25 September 2025

Our Ref: R/2025/4/D
File No: 2025/553139
Your Ref: SSD-79316759

**Advice on Amendment Report – Concept Proposal for mixed-use with time limited
Affordable Housing – 45-53 Macleay Street, Potts Point – SSD-79316759**

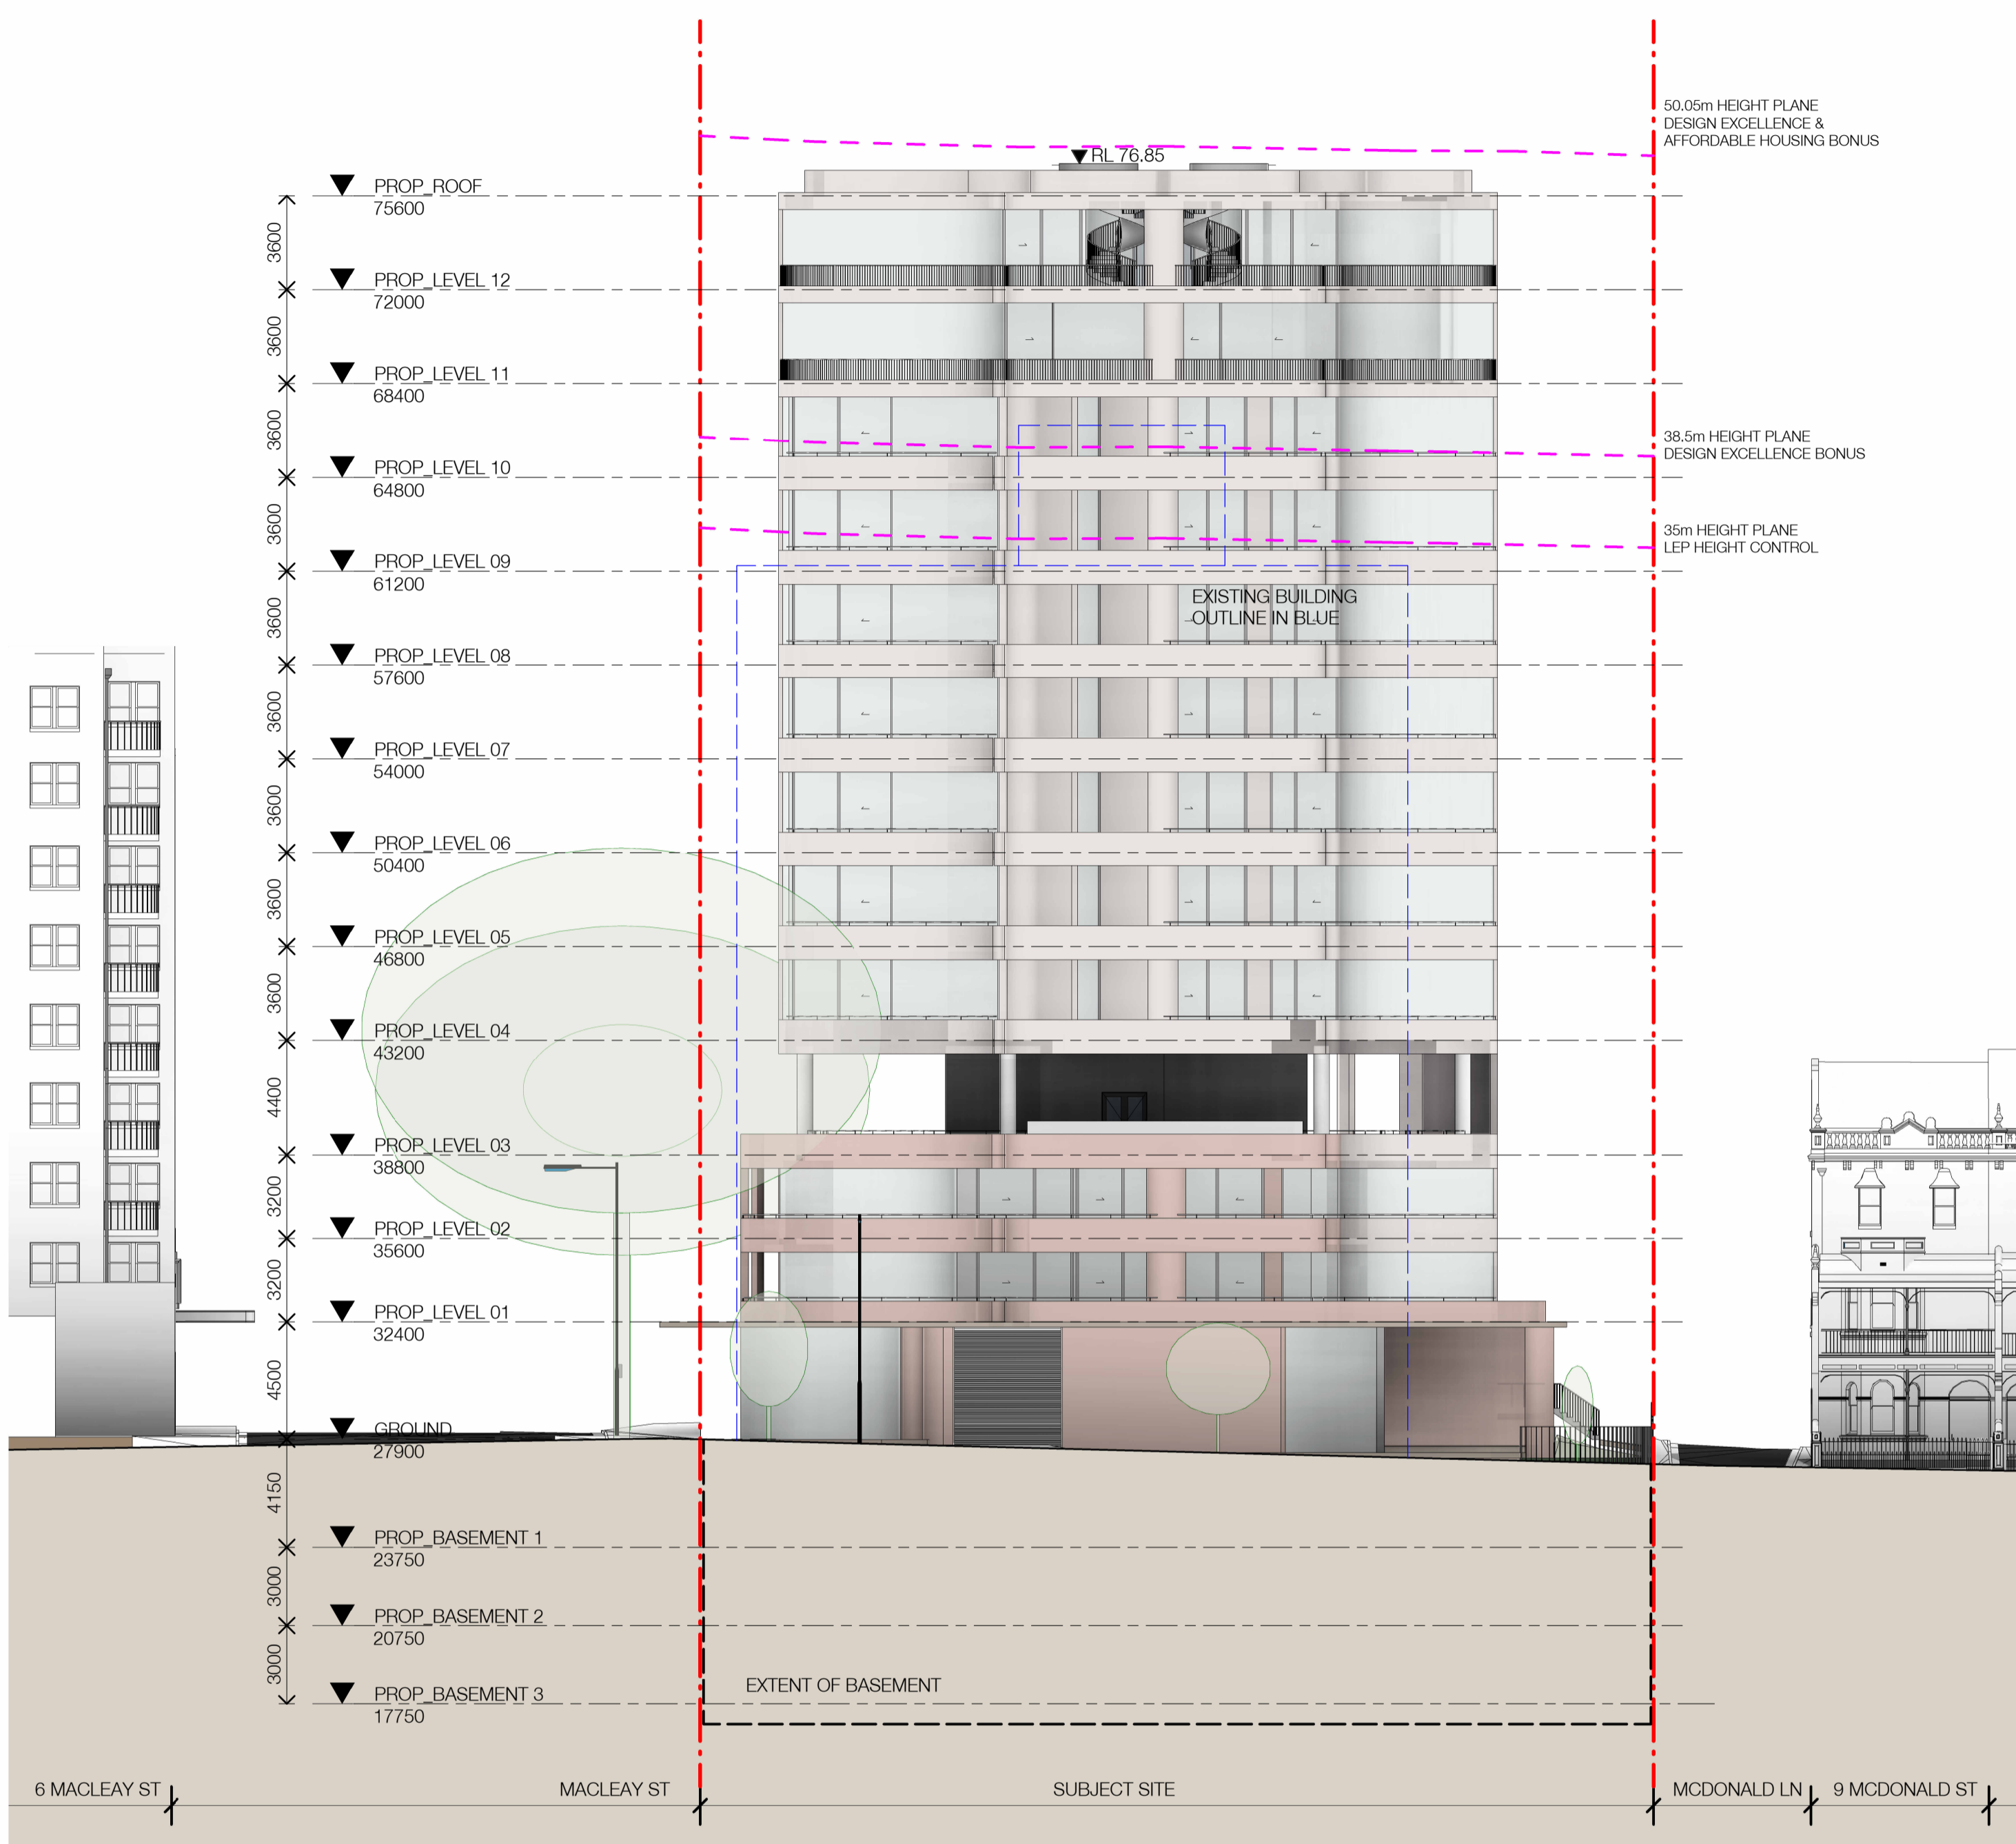
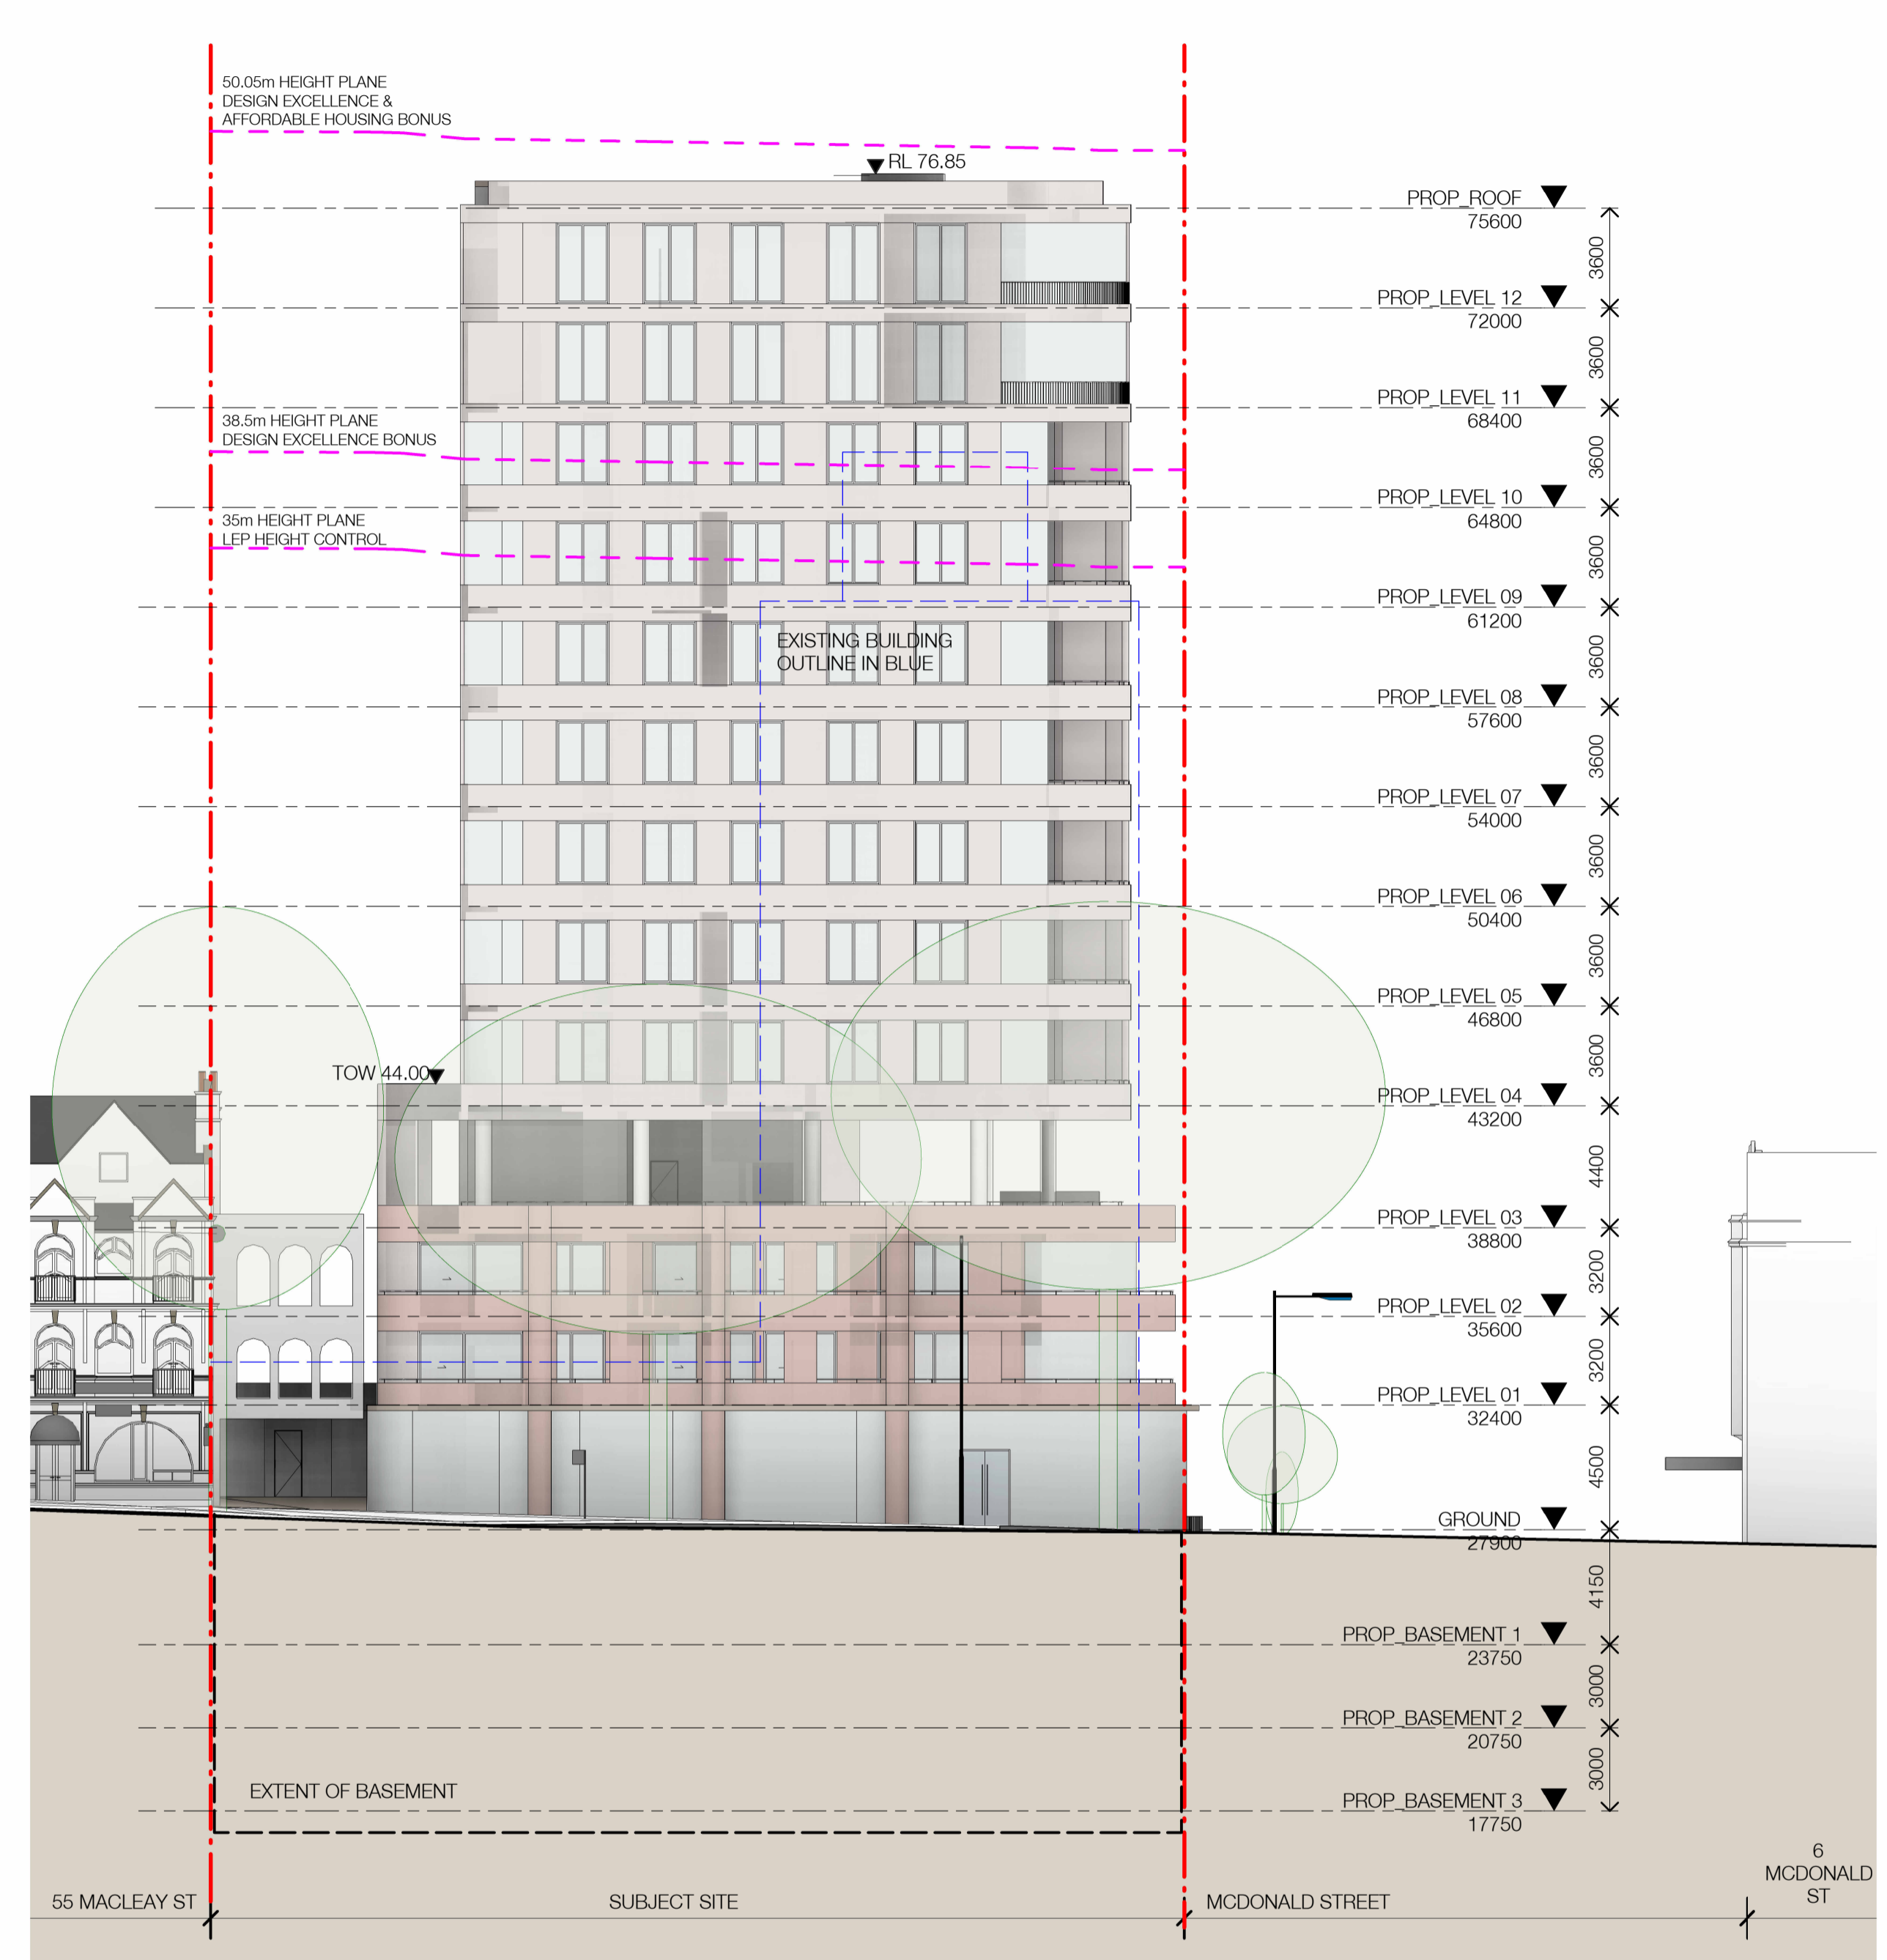
The Amendment Report states that the Stage 1 demolition works only includes demolition of the existing building to the ground floor slab, with no ground disturbance. However, the Demolition Work Plan in Appendix C includes demolition of slab on ground and foundations in section 5. The demolition elevation prepared by SJB does not provide any clarification.

The scope of demolition must be clarified, and all documents must be amended to ensure consistency.
